From: Gillah, Andrew
Sent: 11 January 2021 11:54
To: Bainbridge, Ed
Cc: planning.comments@york.gov.uk; public.protection@york.gov.uk
Subject: 21/00006/FUL - Two storey side and single storey front and rear extensions following demolition of outbuilding. 25 Chaloners Road, York, YO24 2TW

Public Protection's comments on this application are as follows:

PROPOSED GROUND FLOOR

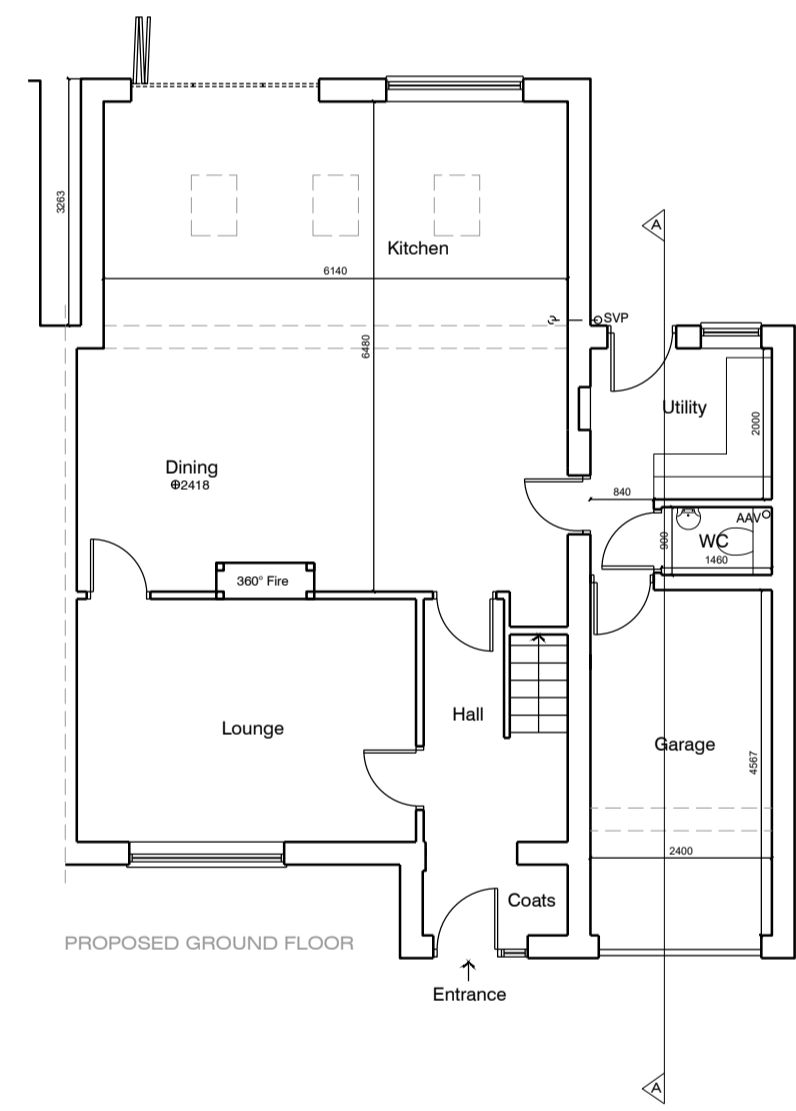
In line with paragraph 110 of the NPPF, developments should be designed to incorporate facilities for charging plug-in and other ultra-low emission vehicles in safe, accessible and convenient locations. Given that the application involves building a new garage and in view of the NPPF and the Council's adopted Low Emission Strategy, which aims to facilitate the uptake of low emission vehicles in York, I would request that the following condition be placed upon any approval given.

- The development shall incorporate sufficient capacity within the electricity distribution board for one dedicated radial AC single phase connection to allow the future addition of an Electric Vehicle Recharge Point (minimum 32A) within the garage / parking area if desired.
